Subject: Junction Rivers Wind Farm (SSD-30448824)

ATTACHMENT A – BCS and NPWS Assessment Summary for Junction Rivers Wind Farm Environmental Impact Statement (SSD-30448824)

ATTACHMENT B – BCS detailed advice for Junction Rivers Wind Farm EIS

Figure A.17 0.2% AEP flood hazard, existing conditions

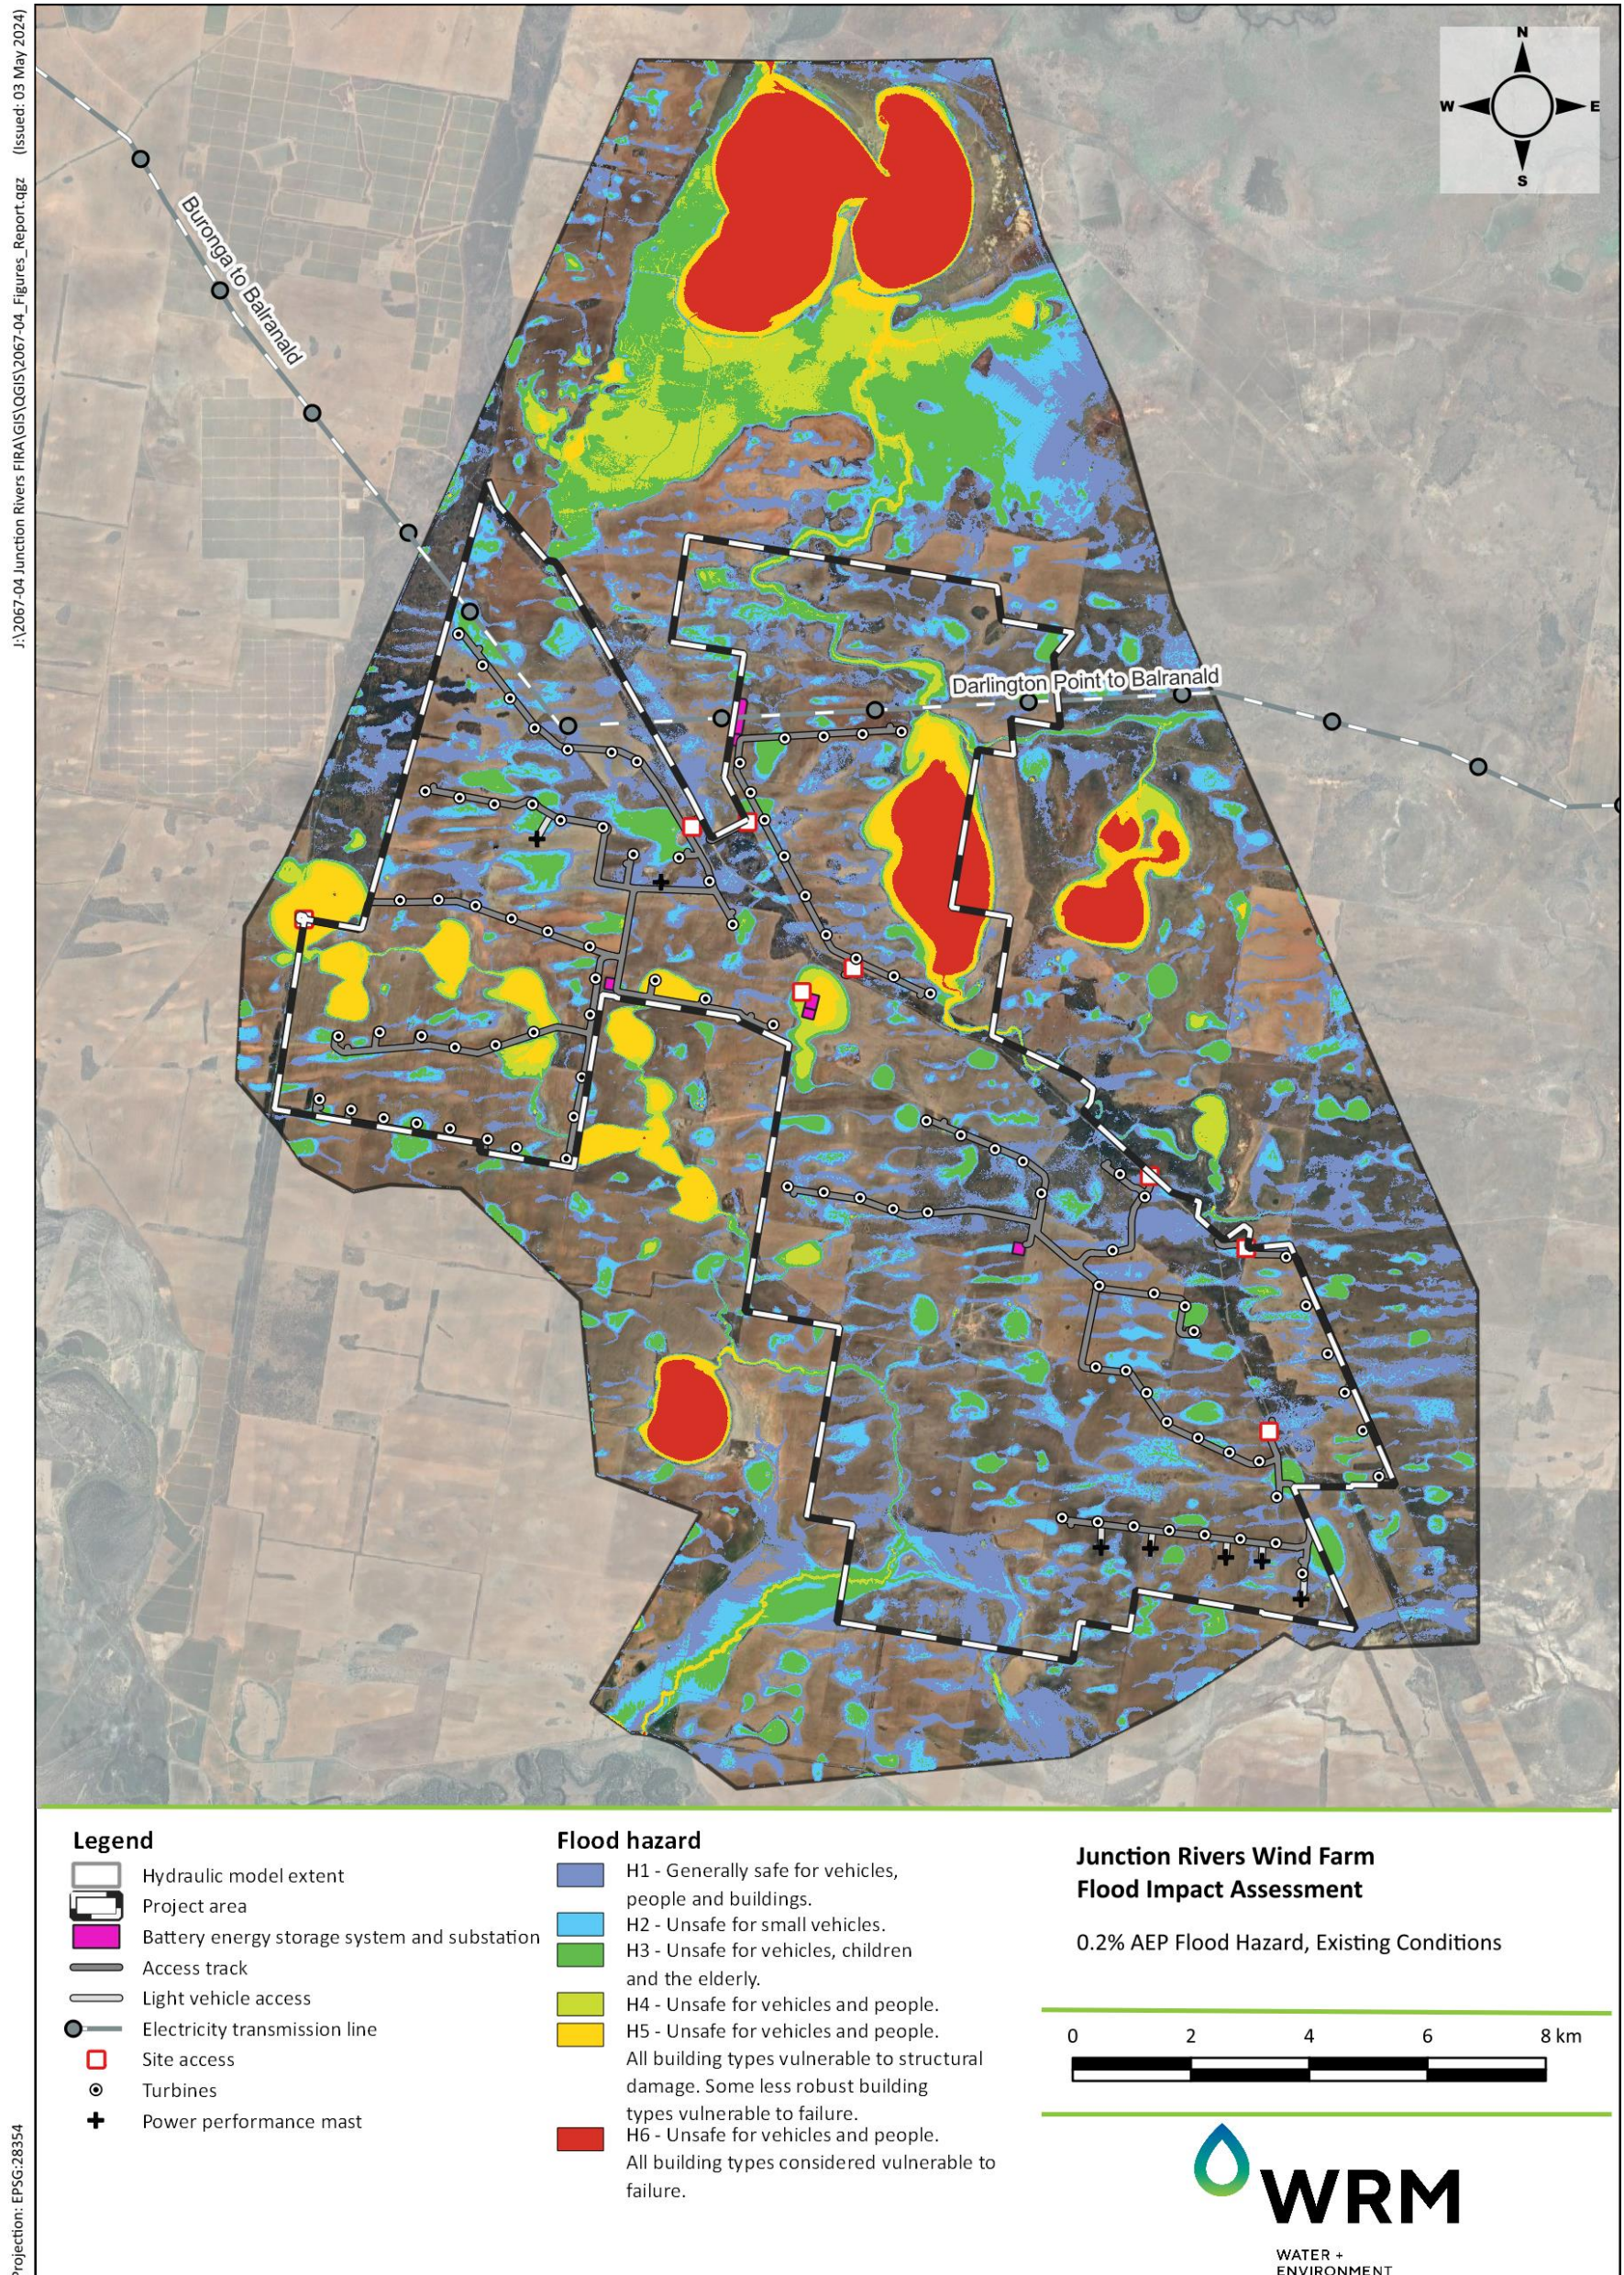
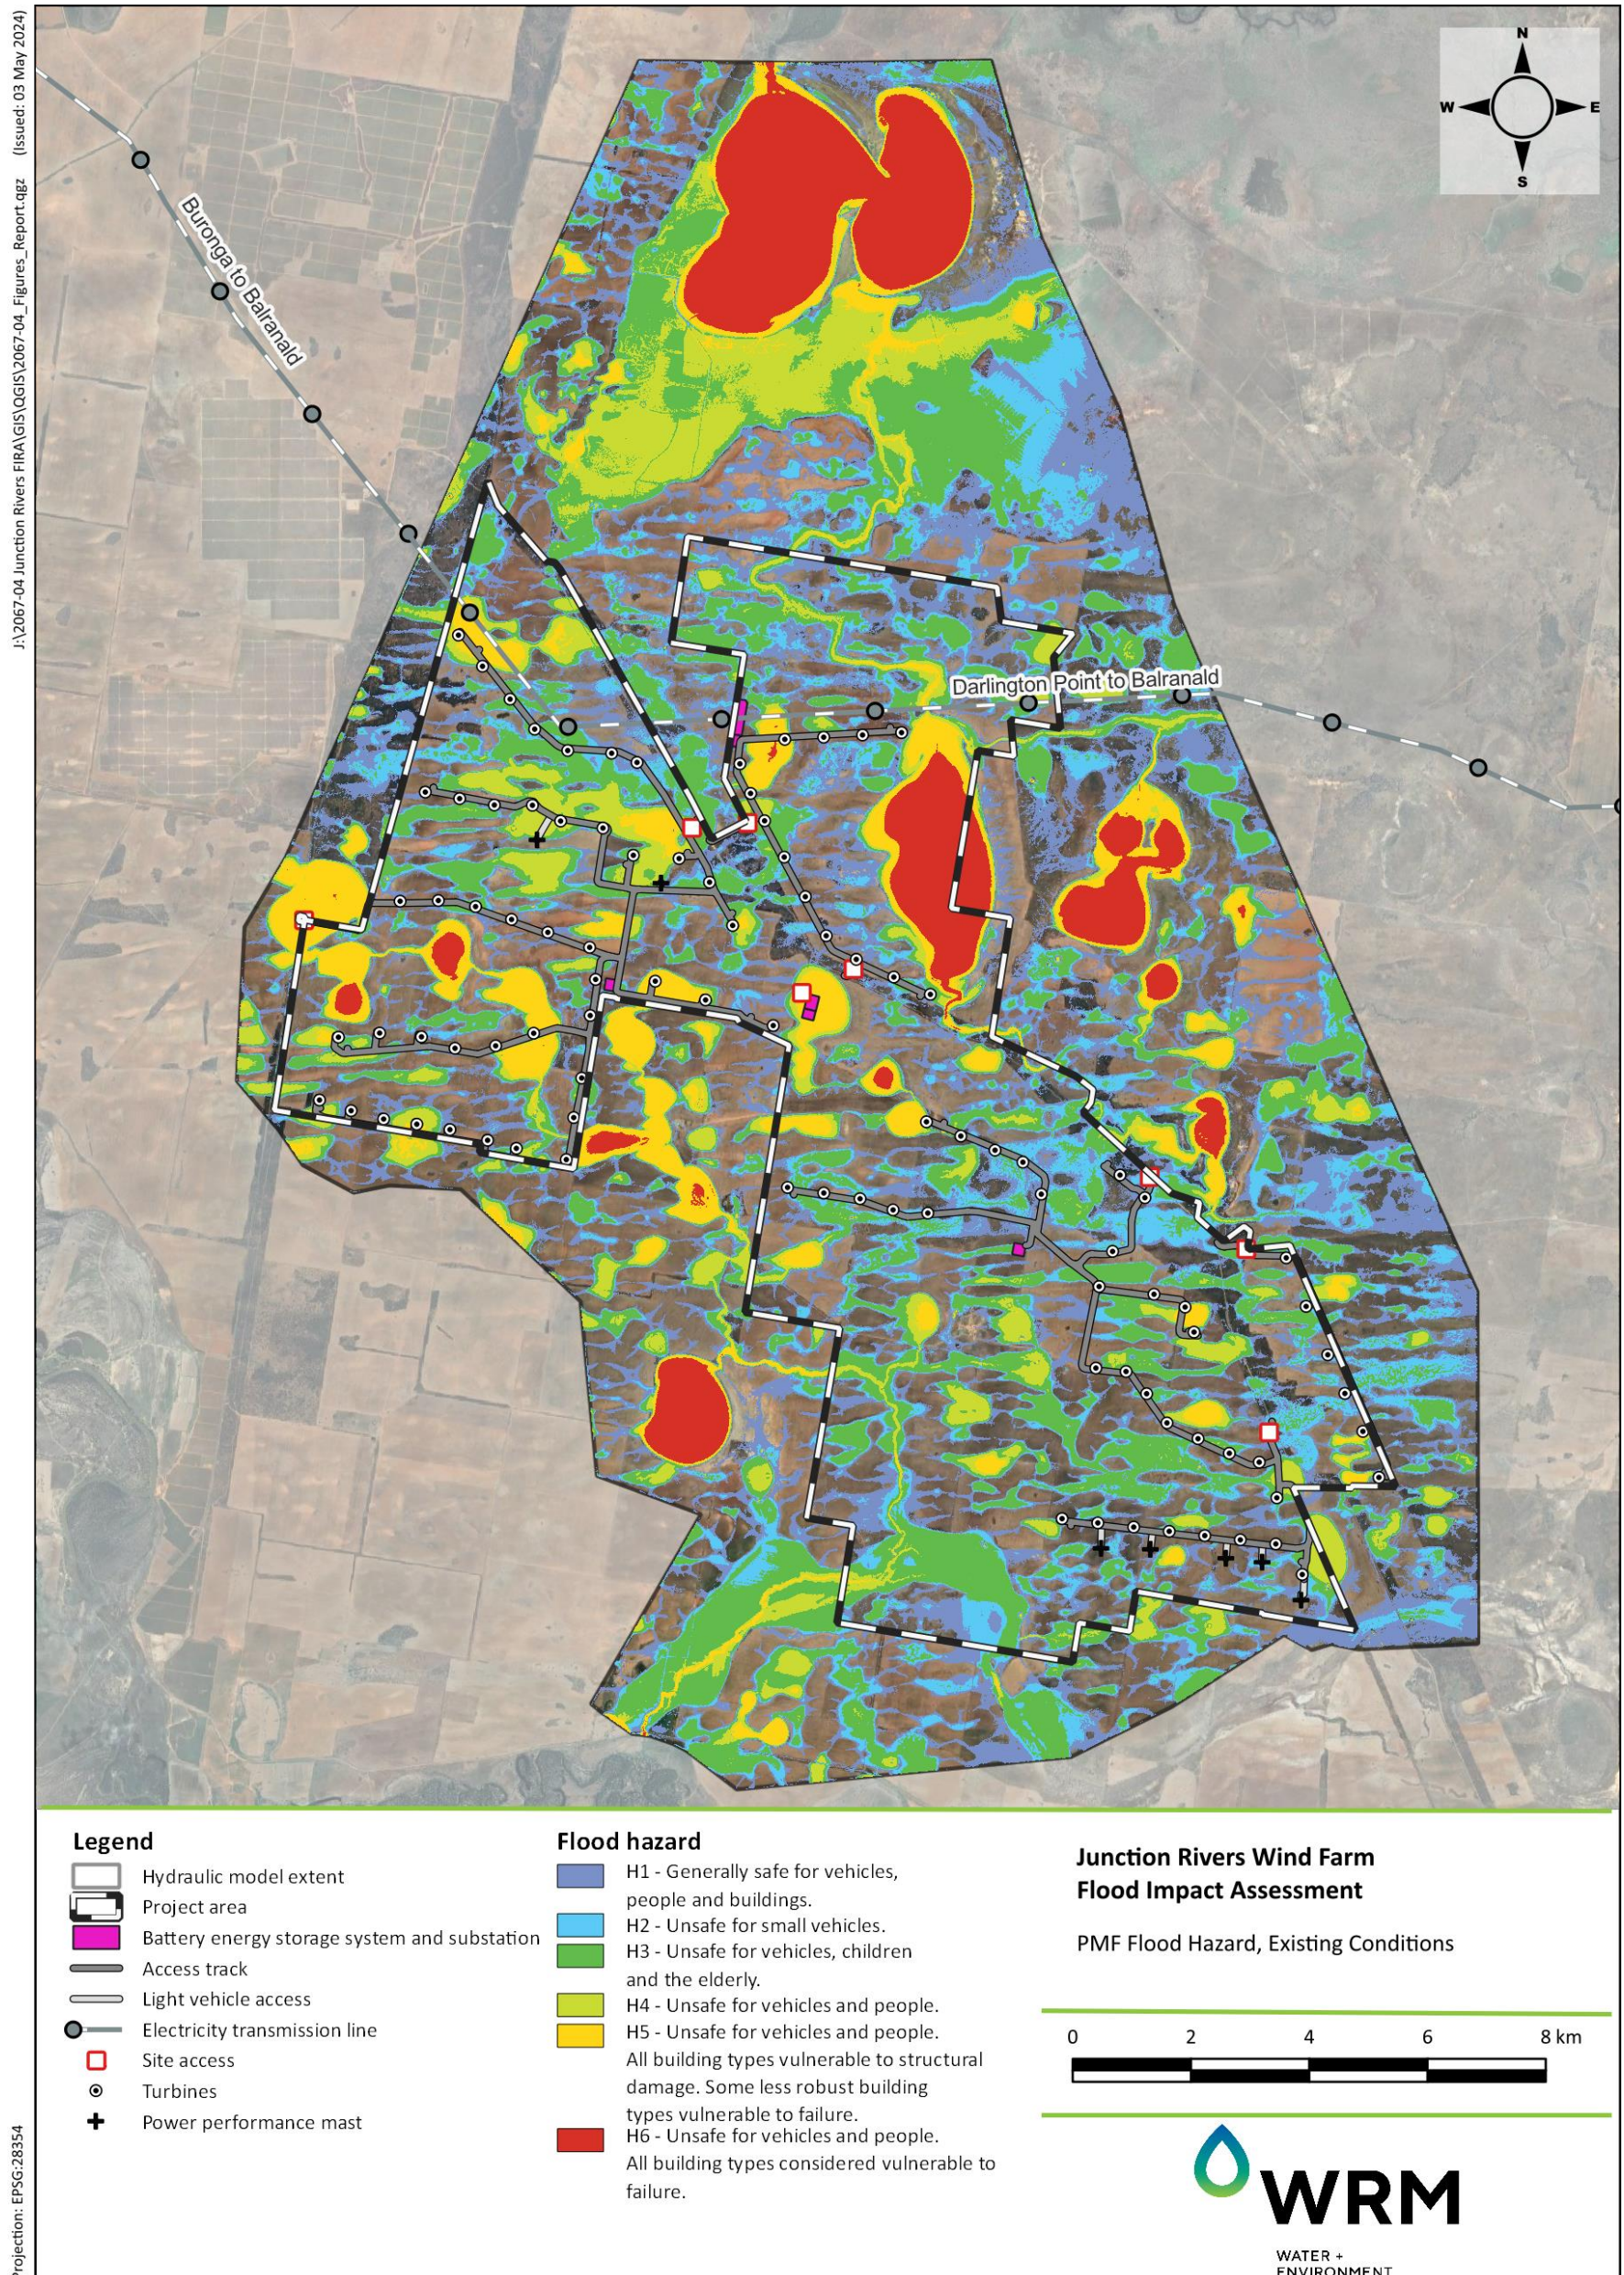
The proposed western and central site access points are located in high flood risk locations as shown in the design flood mapping in the Flood Risk Impact Assessment. BCS considers that these locations are incompatible with use as key evacuation egress routes in major flood events.

BCS recommends that more appropriate locations for flood emergency egress needs to be determined in the detailed design stage in consultation with local Councils and the NSW SES. The flood emergency evacuation egress locations and evacuation procedures need to be detailed in the proposed ERP along with the records of consultation with local Councils and the NSW SES.

- 2.1. Identify more appropriate locations for flood emergency egress for those site access points that are impacted by high flood risks in consultation with local Councils and the NSW SES.
